National Highways Planning Response (NHPR 21-09) Formal Recommendation to an Application for Planning Permission

Council's Reference: 22/01488/OUT

Location: OS Parcel 5616 South West Of Huscote Farm And East Of, Daventry Road, Banbury

Proposal: Construction of up to 140,000 sq. m of employment floorspace (use class B8 with ancillary offices and facilities) and servicing and infrastructure including new site accesses, internal roads and footpaths, landscaping including earthworks to create development platforms and bunds, drainage features and other associated works including demolition of the existing farmhouse.

Frontier Park Infrastructure

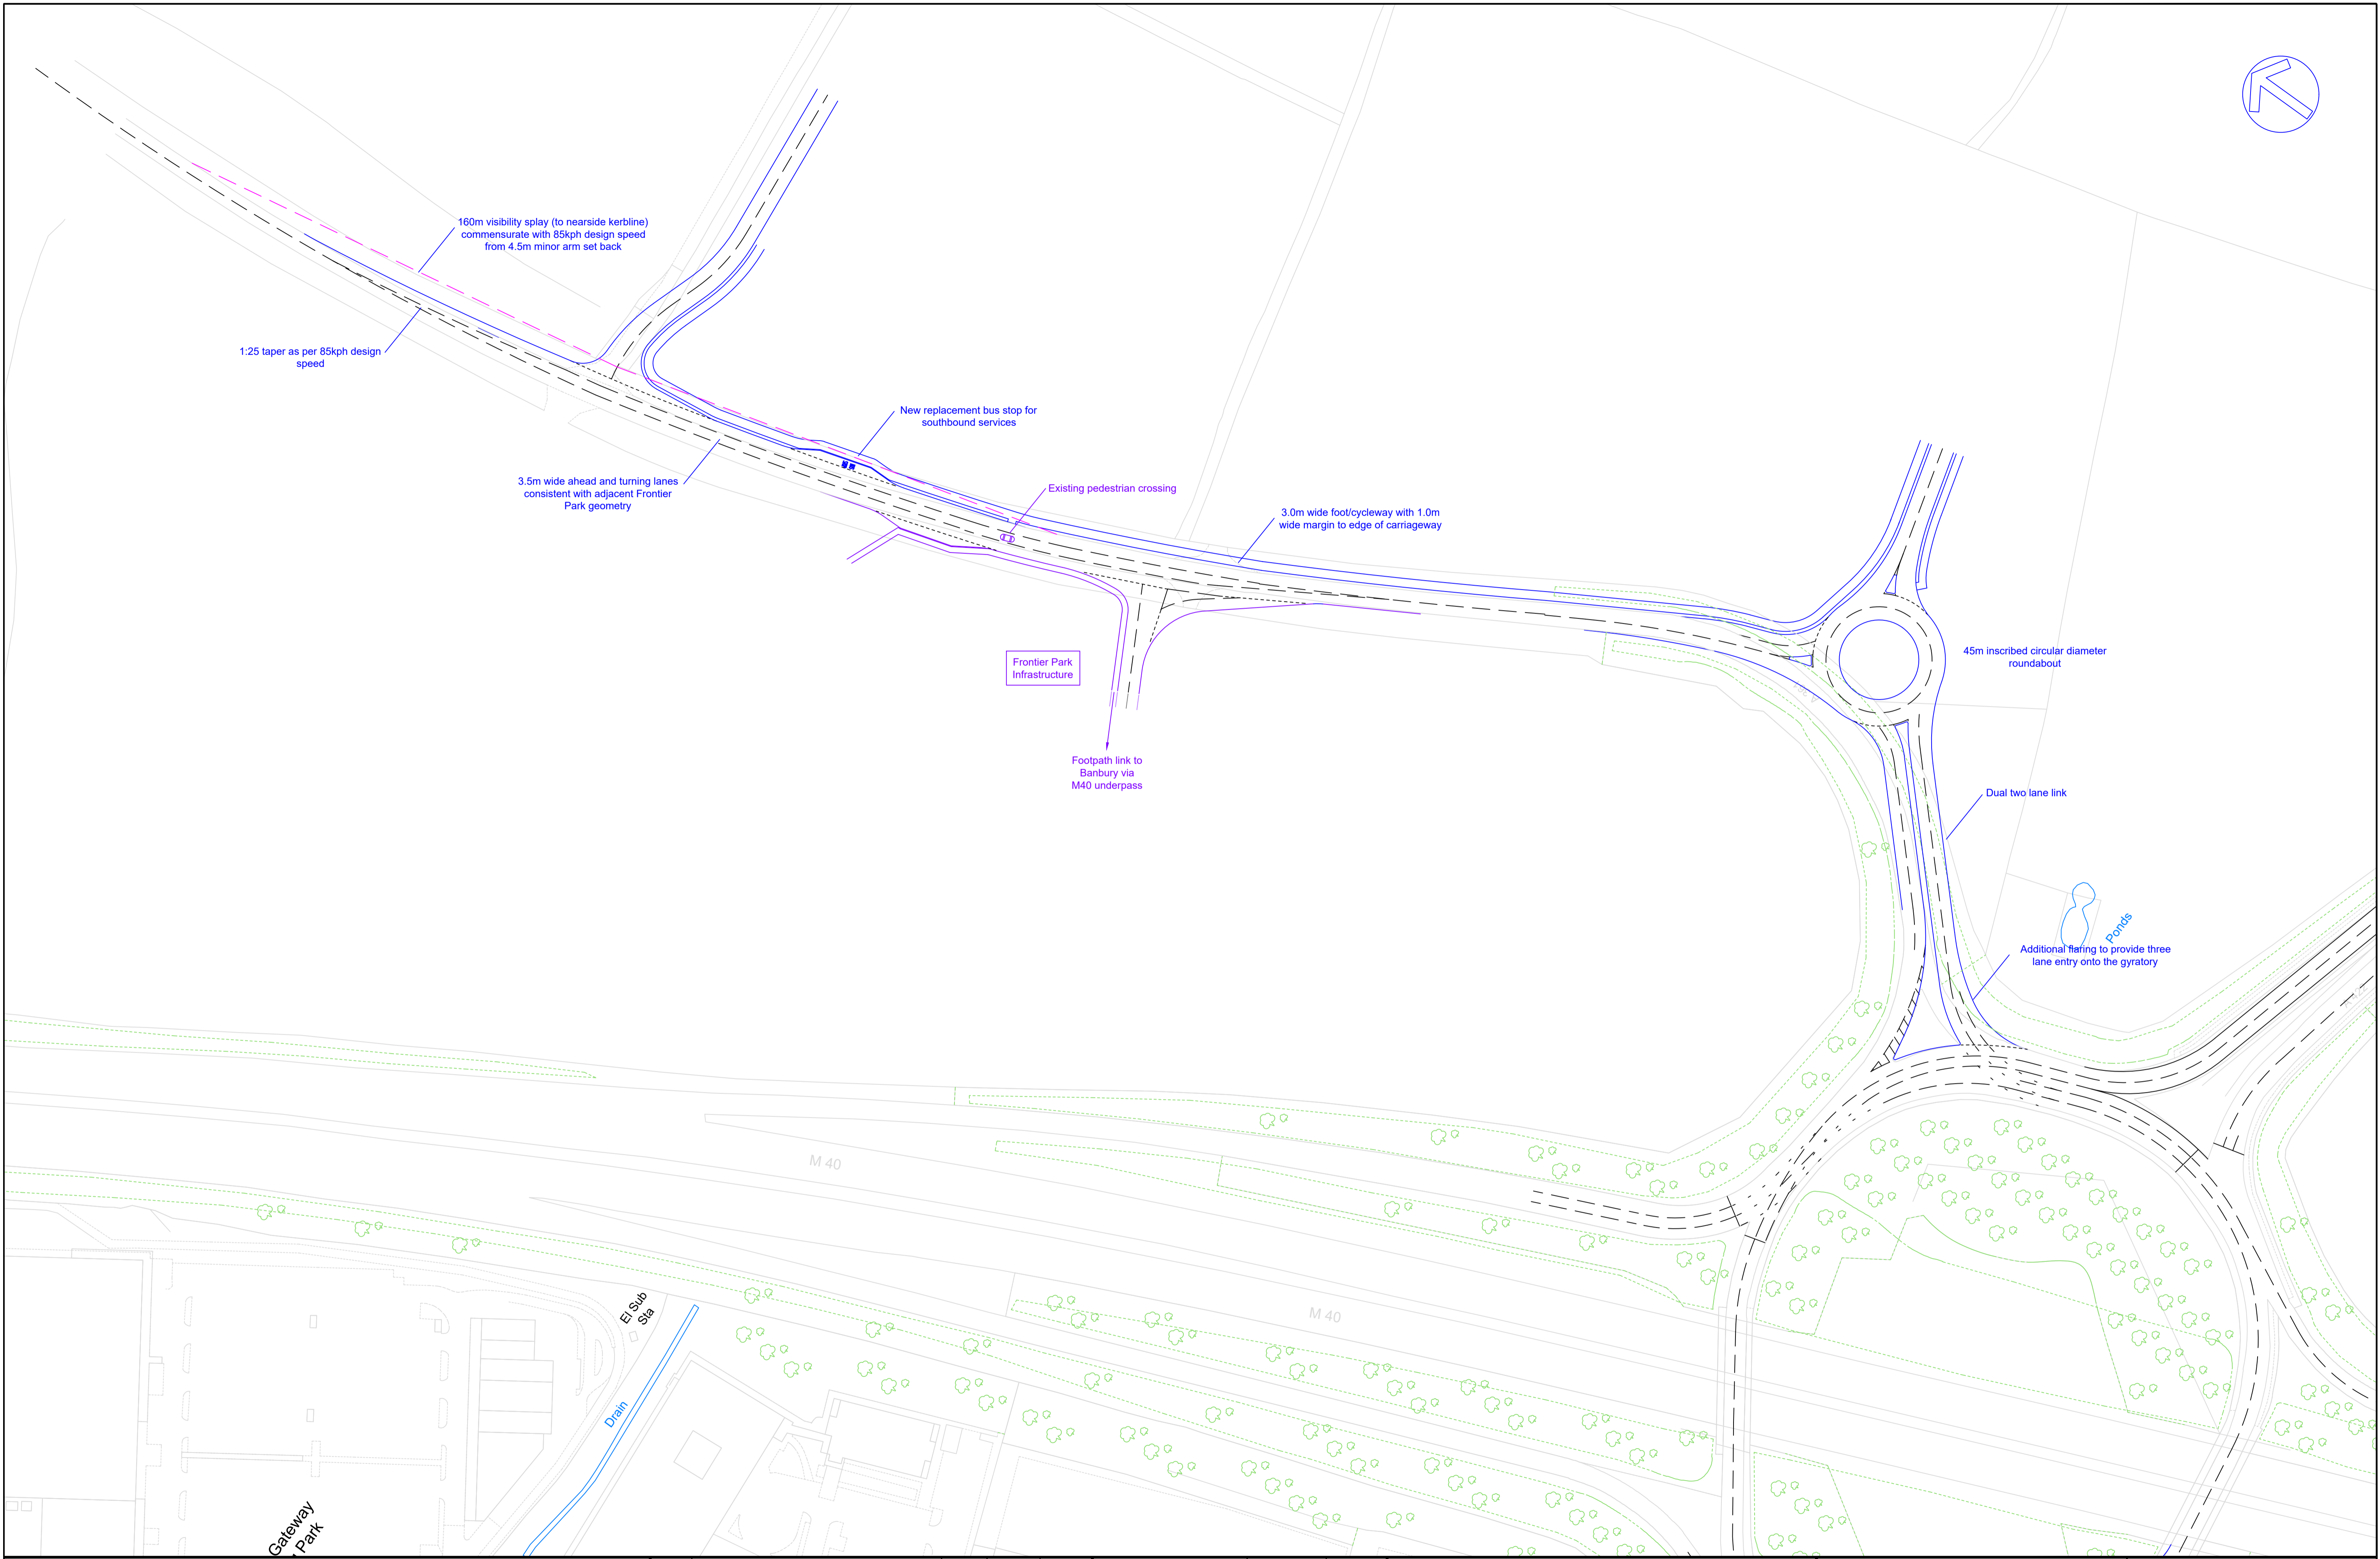
NH has a particular concern that the proposed location of the site access roundabout on the A361, could result in peak hour traffic queuing back onto M40 Junction 11. The LinSig modelling is unable to assess this potential impact and therefore NH require a VISSIM model to determine whether this is likely to be a cause for concern.
